Application No: AB/114/20/PD
Site Address: Riverside House 2 Fitzalan Road Arundel BN18 9JS
Description of works: Notification for Prior Approval under Schedule 2 Part 1 Class AA for a additional 2 storeys on existing dwelling house.

Thank you for your internet representation made on 29th November 2020 which has been recorded as an objection with the comments as follows:

Drawing Title:
PROPOSED ELEVATIONS

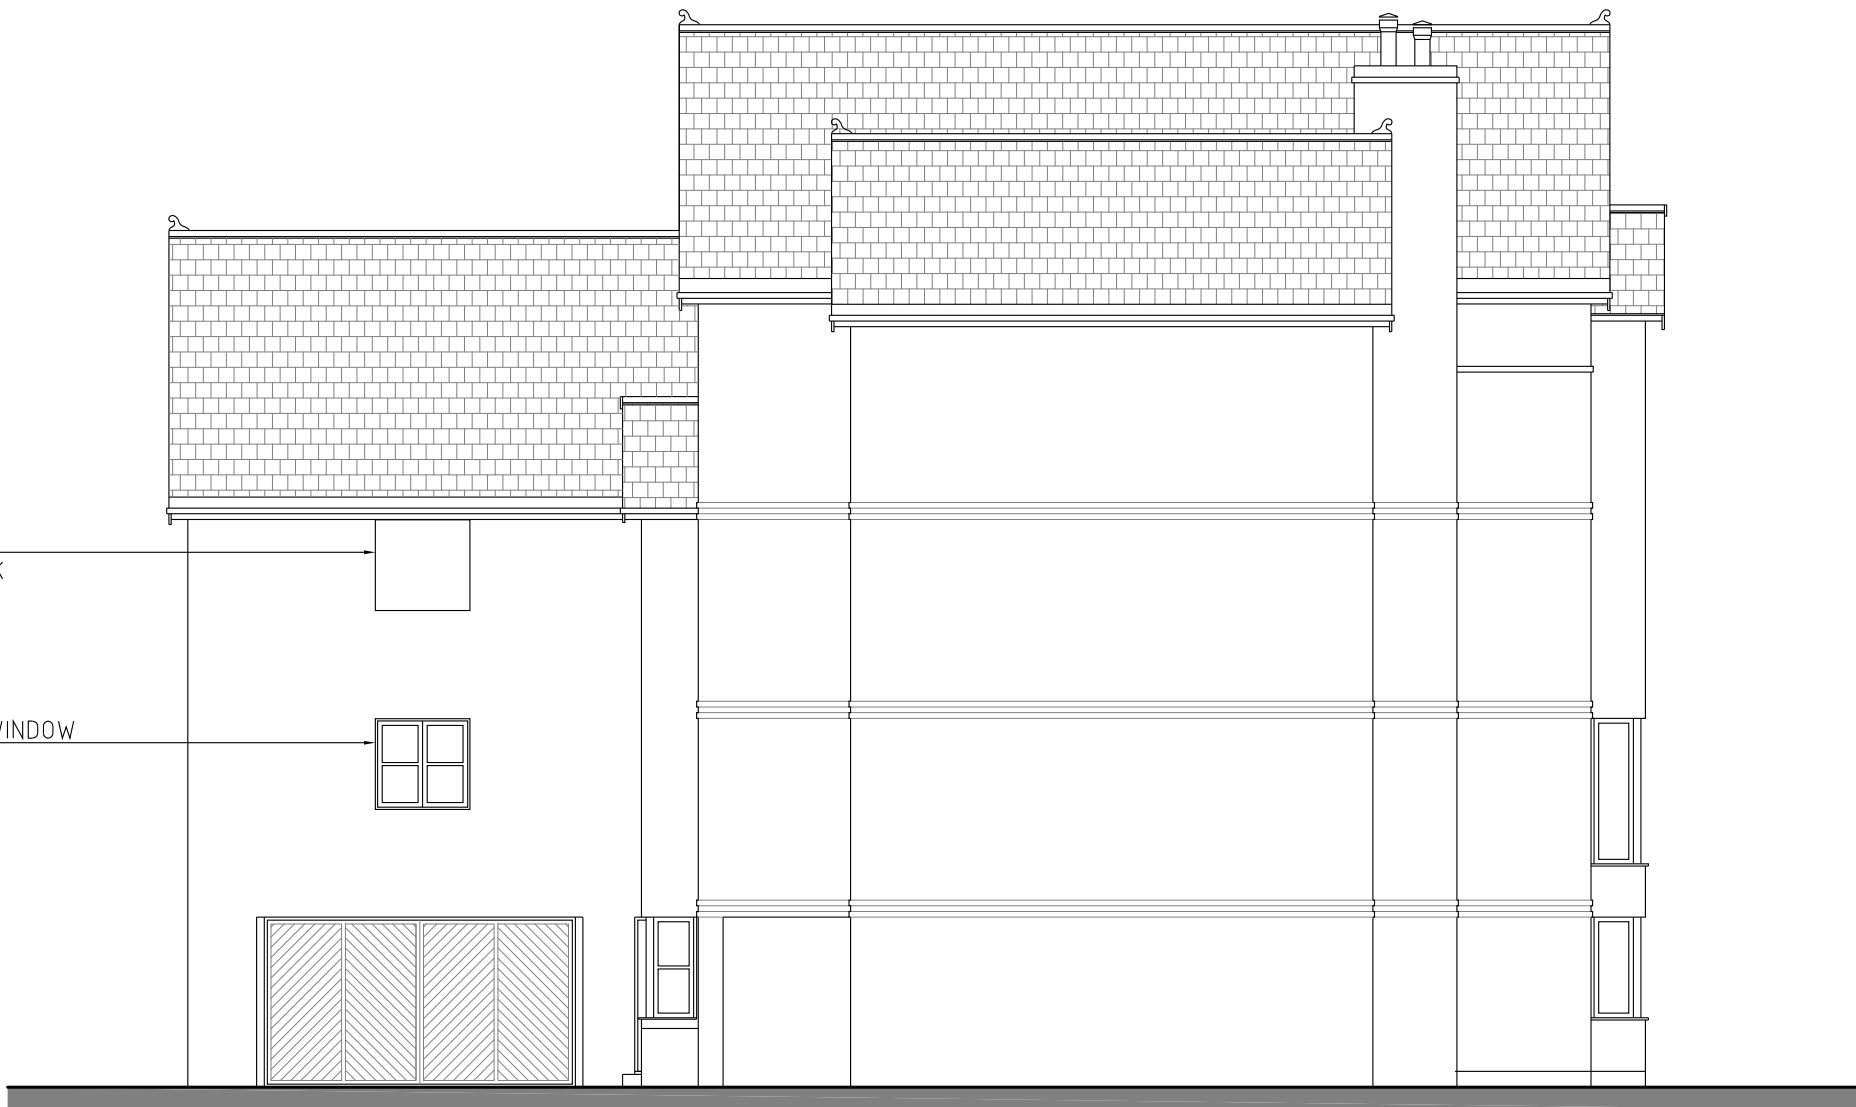
The proposed two storey extension by reason of its site coverage, bulk, height, proximity to the site boundaries and location close to the Arundel Conservation Area would result in a prominent and obtrusive dwelling which would adversely affect the visual amenities and the character of the area and would not preserve or enhance the setting of the Conservation Area. It would therefore be contrary to policies AREA 2, GEN 7, and DEV 19 of the Arun District Plan and the National Planning Policy Framework.
